ENG-MS21002-R2-FDR.pdf Markup Summary

Engineering Review
06/28/2021 6:07:51 PM
dsdrice
JedRice@epcinc.com
(719) 530-7877
EPC Planning & Community
Development Department

ROADSIDE DITCH CONVEYANCE EXHIBIT

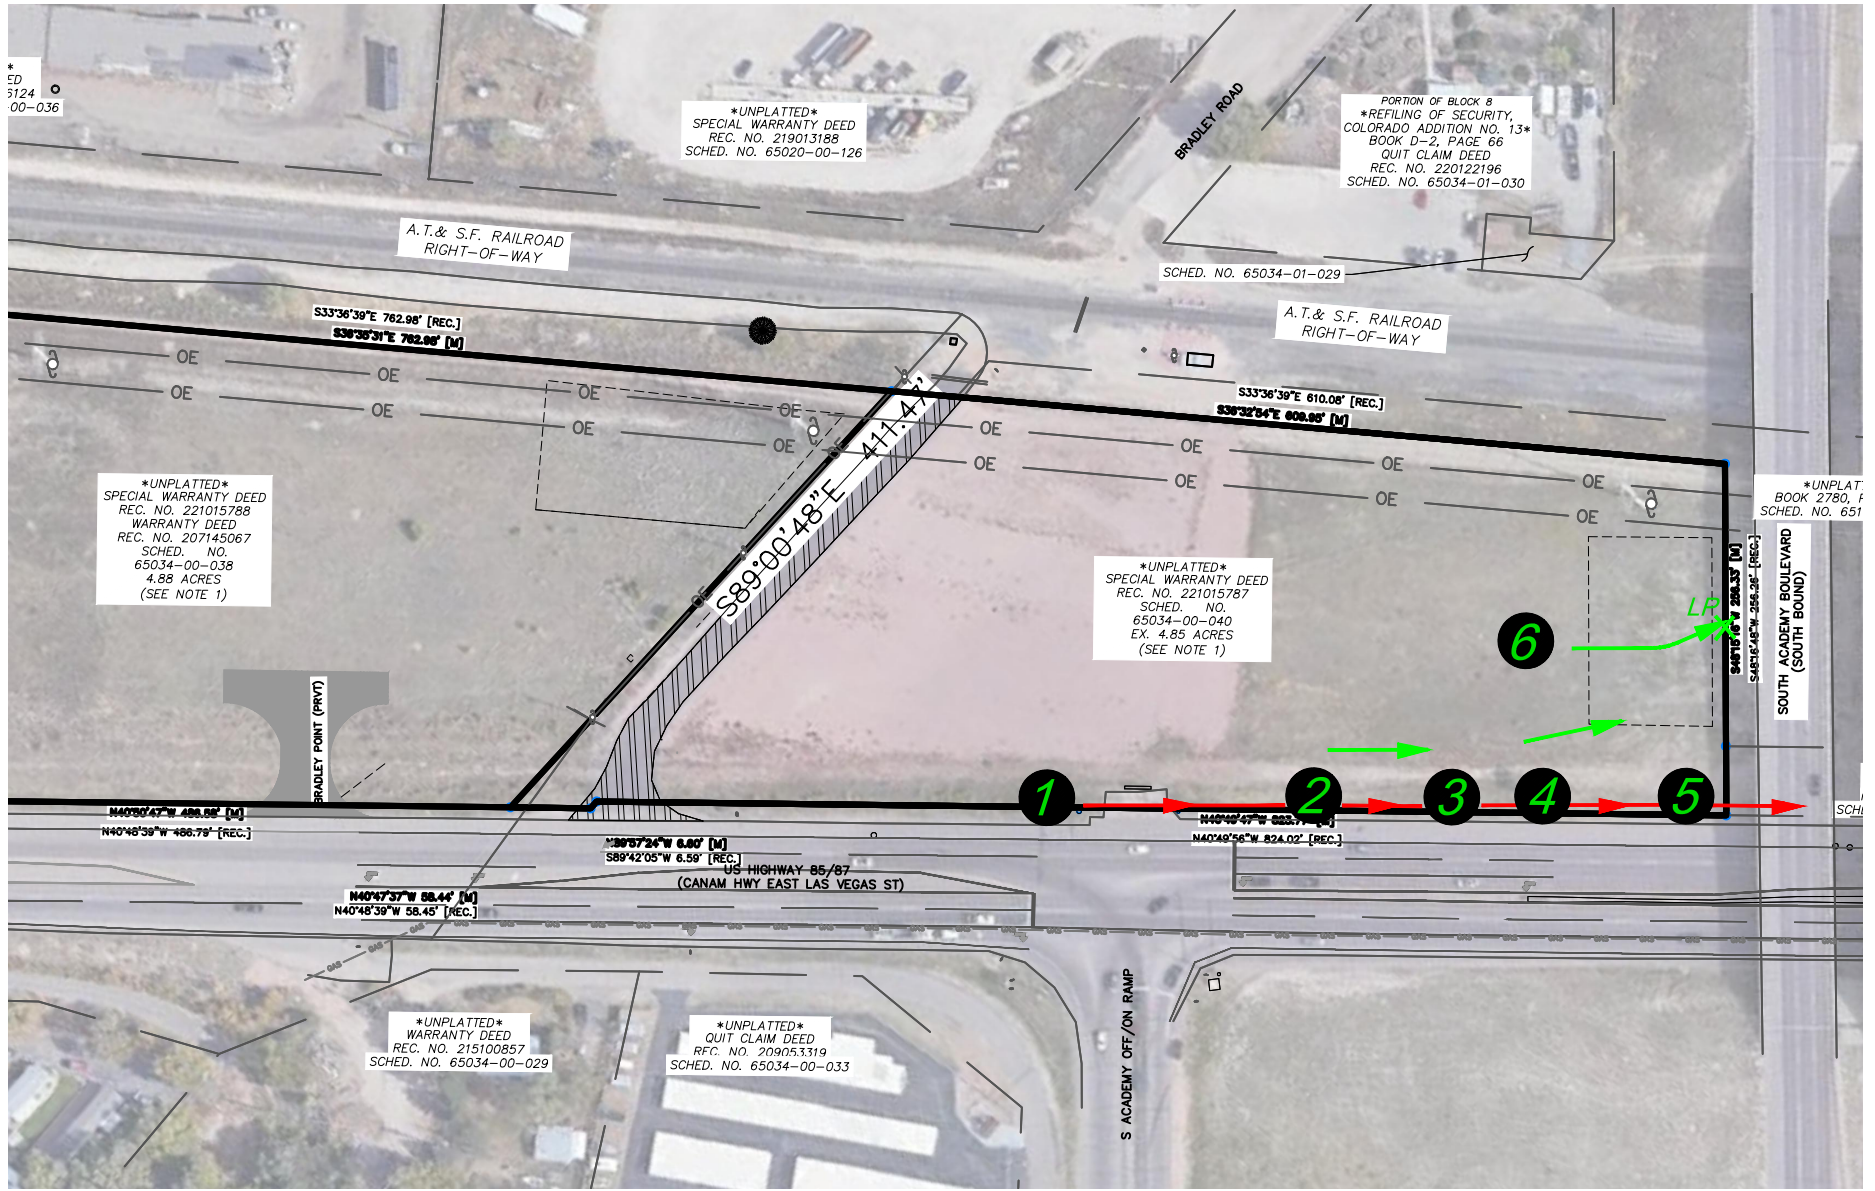
Gravel is 80%, plus pavement per DCM Update Section 3.1: "Gravel parking areas, storage areas, and access drives proposed on Site Improvement Plans shall be analyzed based on an imperviousness of 80%. This is due to the potential for gravel areas being paved over time by property owners and the resulting adverse impacts on the stormwater management facilities and adjacent properties."

verify based on gravel imperviousness comments

~40% impervious?
See comment letter.

BRADLEY POINT FILING NO. 1 - PROPOSED DRAINAGE MAP

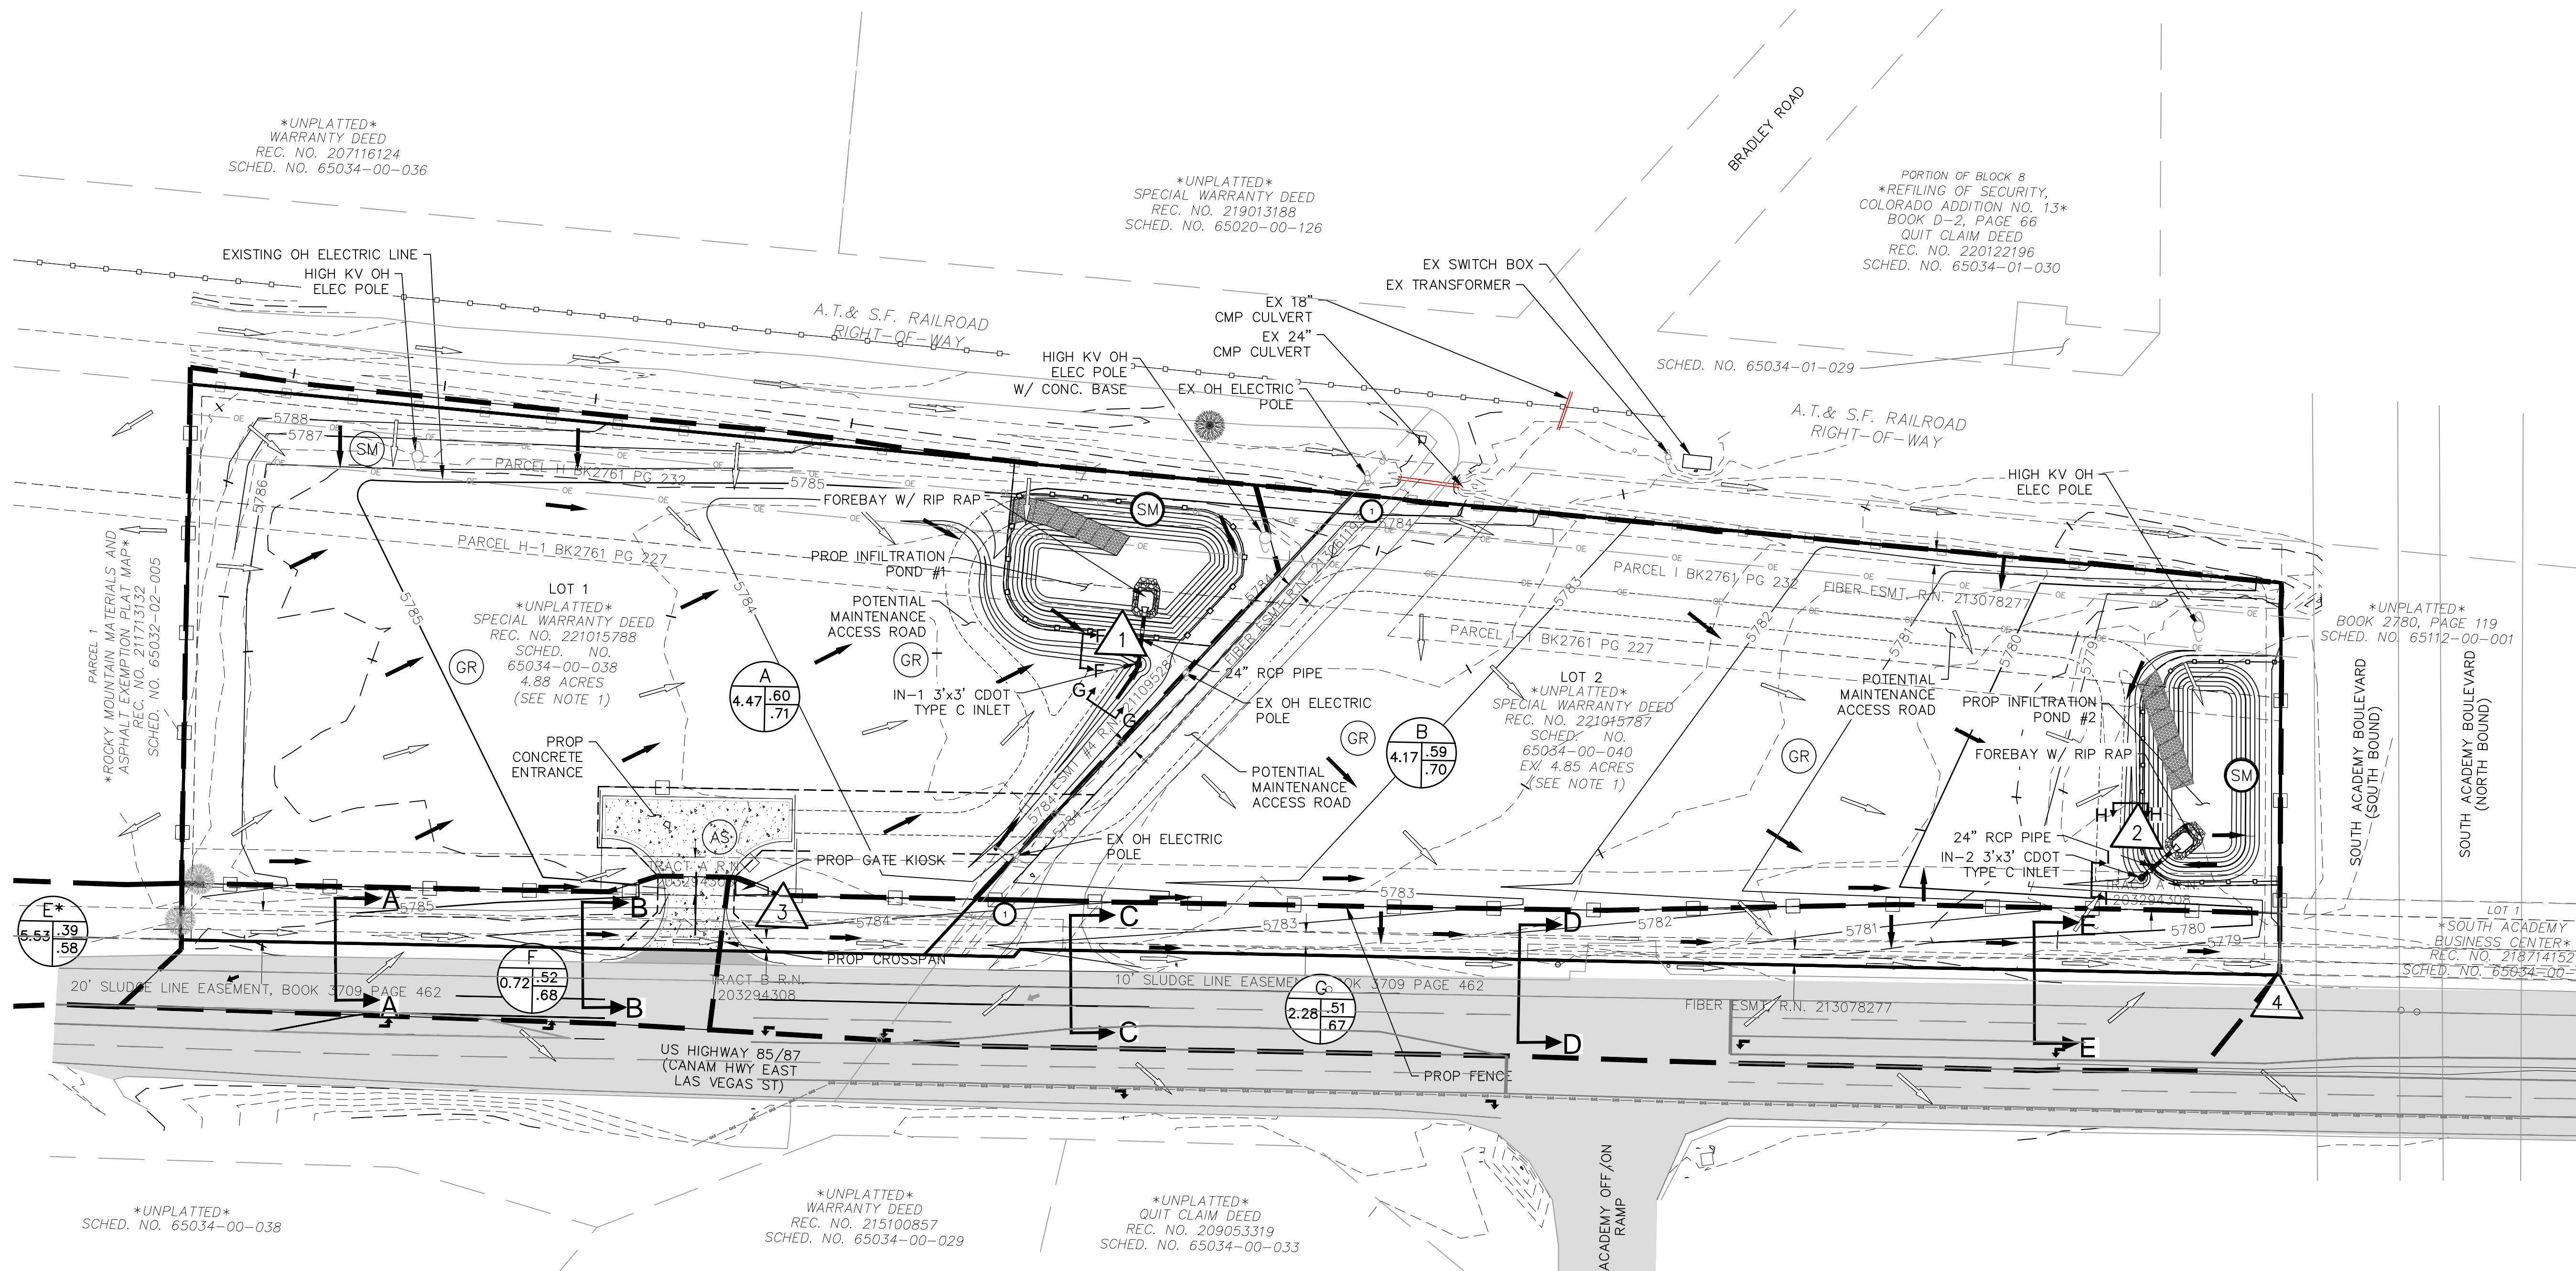
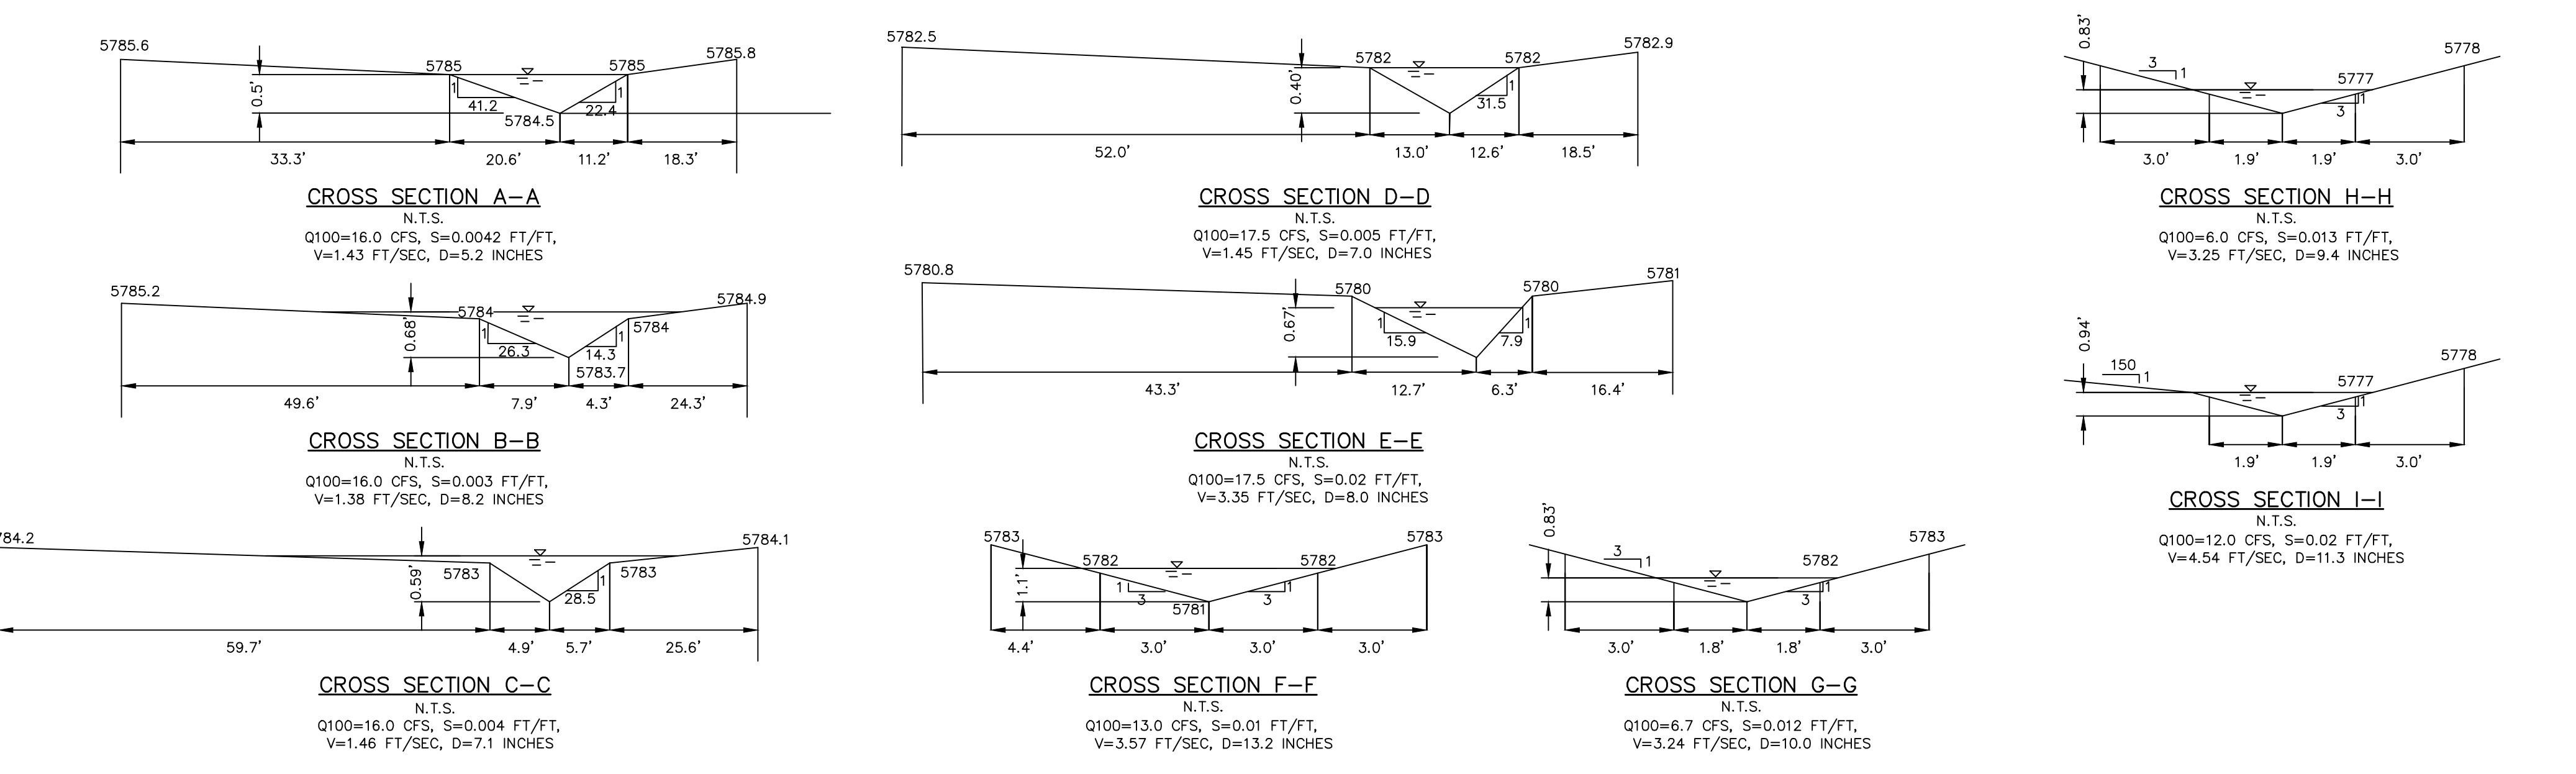
Provide detail and cross-section for level spreader in the FDR and on the GEC Plan. Show how the level spreader will match existing grade on the cross-section

If offsite grading is necessary provide proof of permission.

Provide spillway cross-sections and show erosion protection
